The Coal
Authority

23rd November 2023

PLANNING APPLICATION: 2021/1089

Hybrid Application comprising of a) Full planning permission for: earthworks to create development platforms; drainage features, including dry detention basin, embankments, bunds, location of strategic landscaping, ecological areas and access. b) Outline planning permission seeking approval for employment use development (use classes E/B2/B8) and associated servicing and infrastructure works, including car parking, vehicle, pedestrian and cycle circulations, on-plot landscaping, noise mitigation, drainage features and all associated infrastructure. (Amended Description and Amended Plans) - Land to the South East of Higham Common Road, Barnsley (Employment) – Re-consultation

Drawing Title
 CONCEPTUAL GEOLOGICAL
 GROUND MODEL - COAL MINING
 RISKS
 (BASED ON RECORDED
 INFORMATION ONLY)

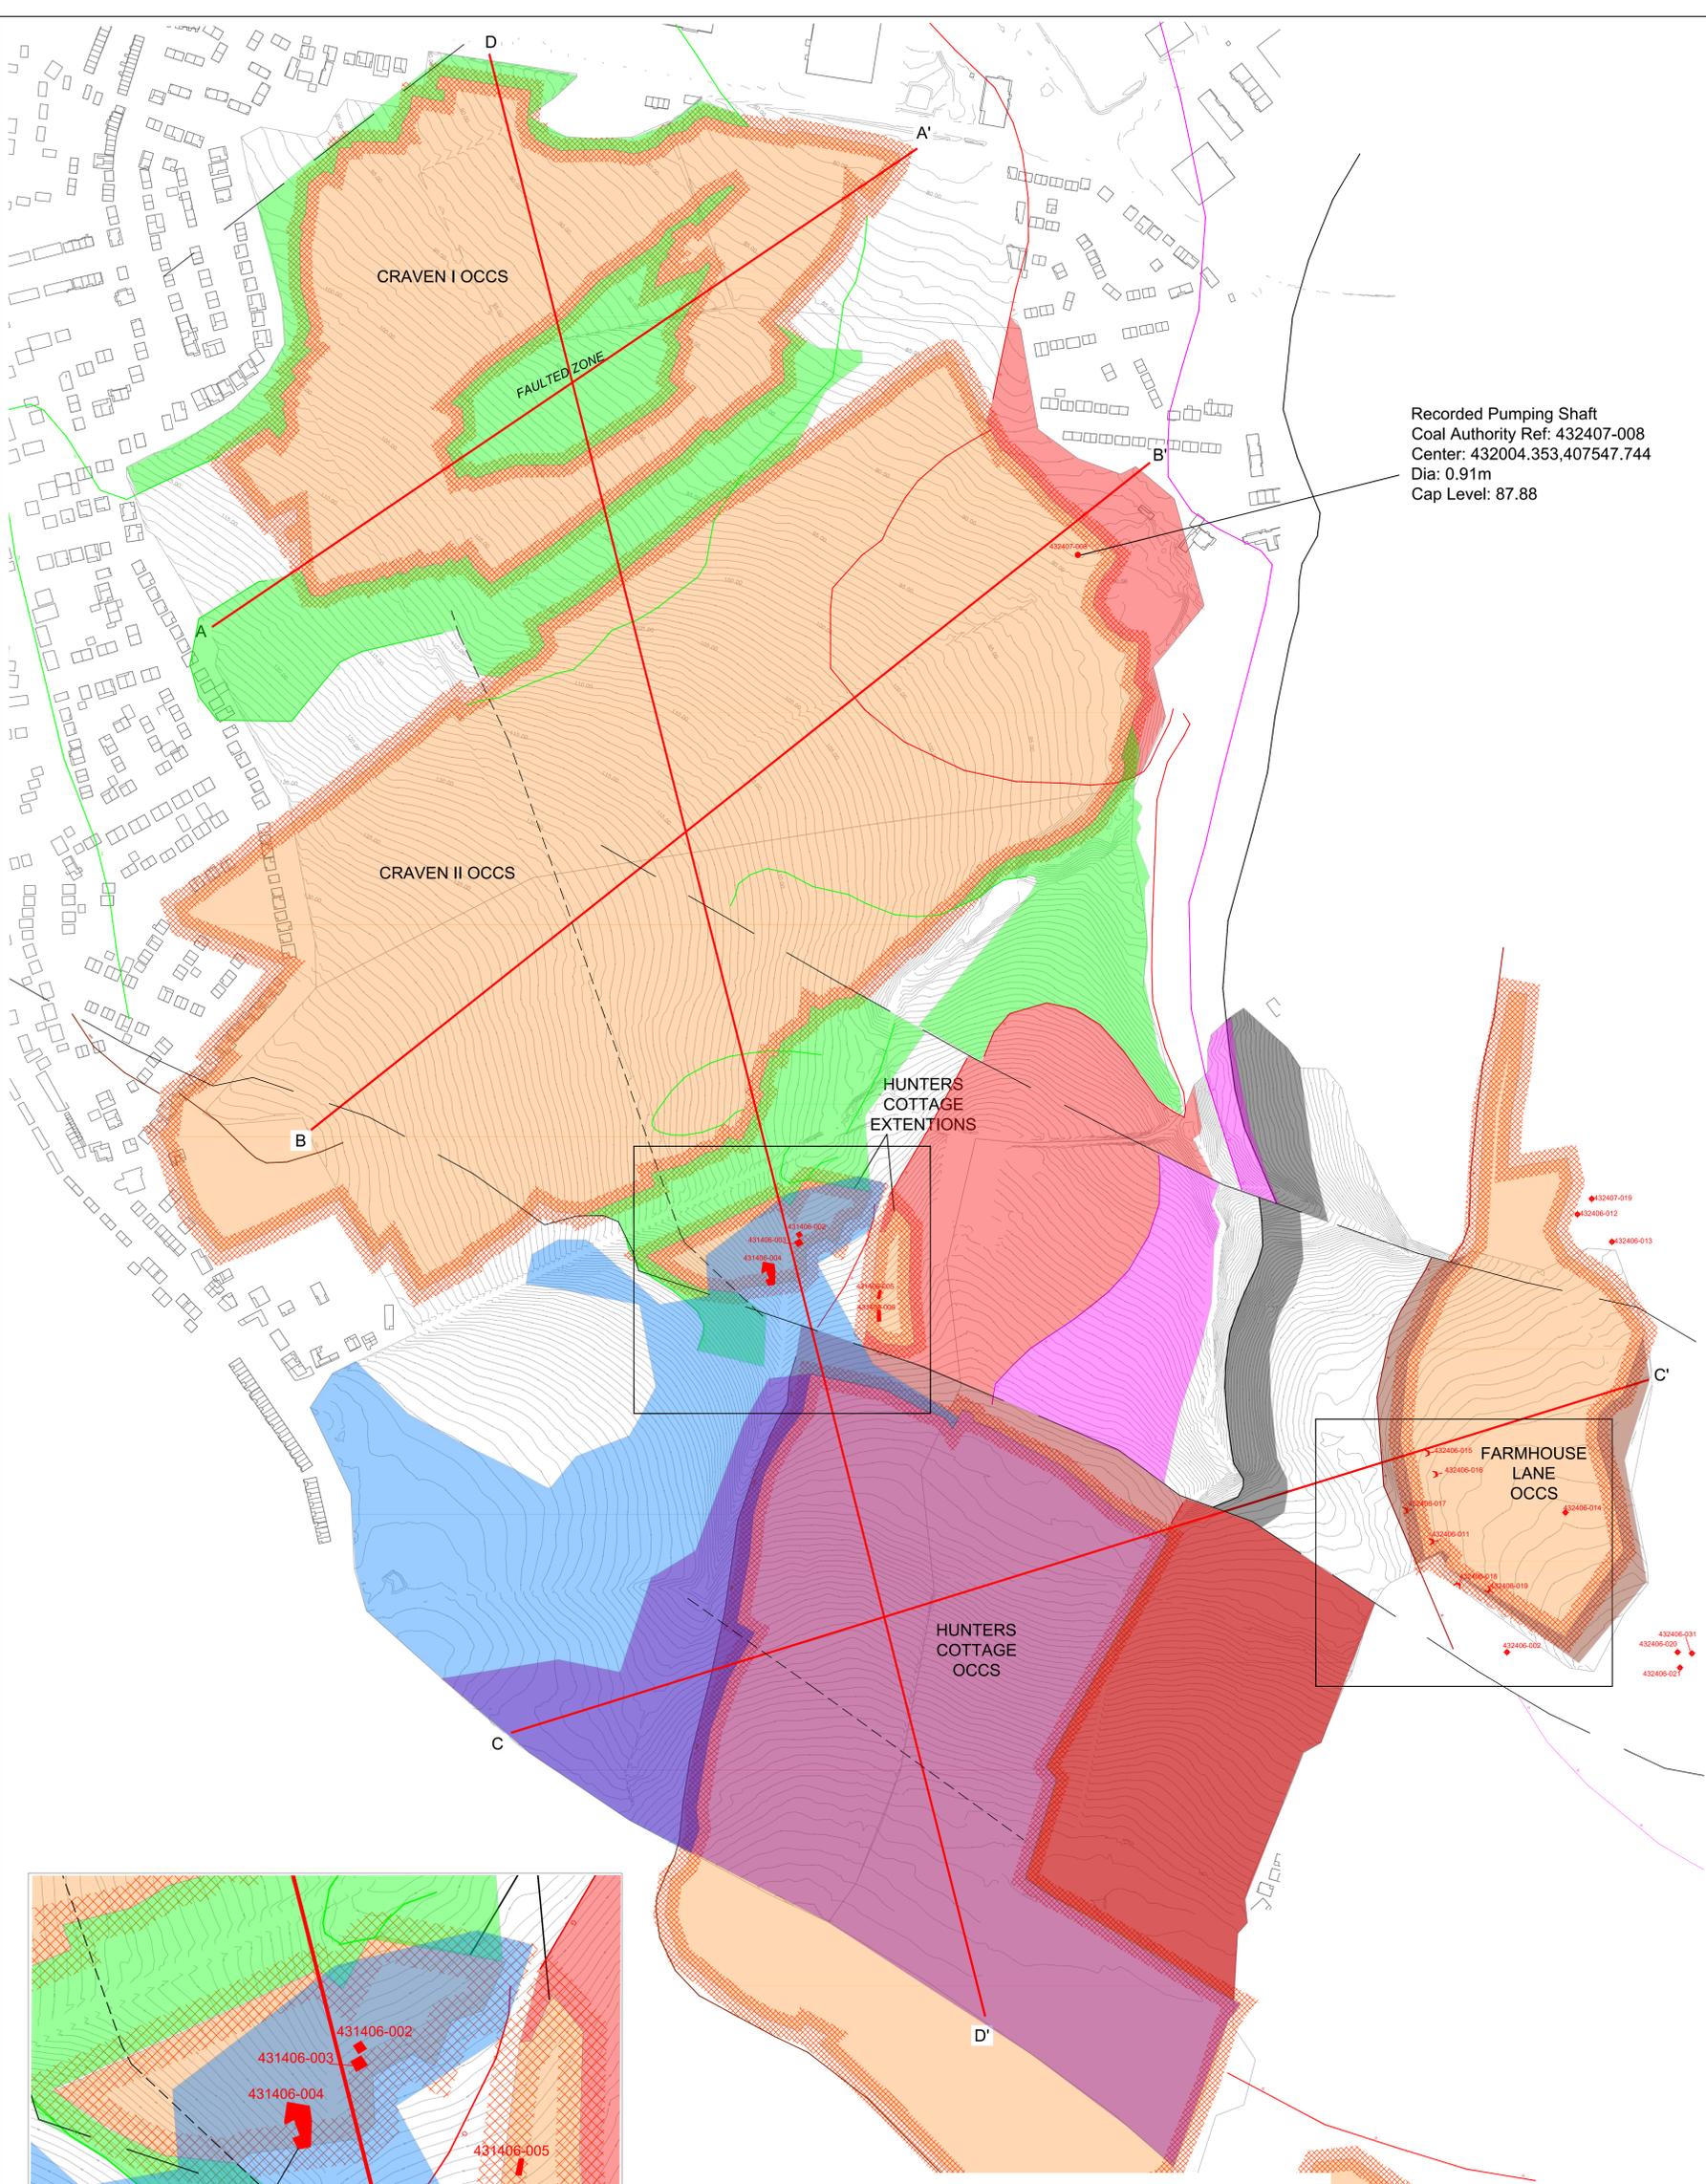
The March 2023 sets out details of the investigatory works undertaken. In respect of coal mining legacy features it states that rotary boreholes are required to confirm the mining legacy and inform the remedial works necessary and delineate the surface mining highwalls. We therefore reiterate our previous comments.

The Coal Authority would expect the location of the surface mining highwalls to be used to inform the layout in order to avoid buildings straddling the highwalls where this is possible.

- 1. *No works shall commence on creating the development platforms until;***
 - a) a scheme of intrusive site investigations has been carried out on site to establish the risks posed to the development by past coal mining activity, and;***
 - b) any remediation works and/or mitigation measures to address land instability arising from coal mining legacy, as may be necessary, have been implemented on site in full in order to ensure that the site is made safe and stable for the development proposed.***

- 2. *Prior to the submission of the first of the reserved matters a signed statement or declaration prepared by a suitably competent person confirming that the site is, or has been made, safe and stable for the approved development shall be submitted to the Local Planning Authority for approval in writing. This document shall confirm the methods and findings of the intrusive site investigations and the completion of any remedial works and/or mitigation necessary to address the risks posed by past coal mining activity.***
- 3. *As part of the reserved matters, for each phase if necessary, a plan should be submitted to the local planning authority for consideration and approval, which demonstrates how the development layout has taken account of any coal mining features present (e.g surface mining highwalls, mine entries).***
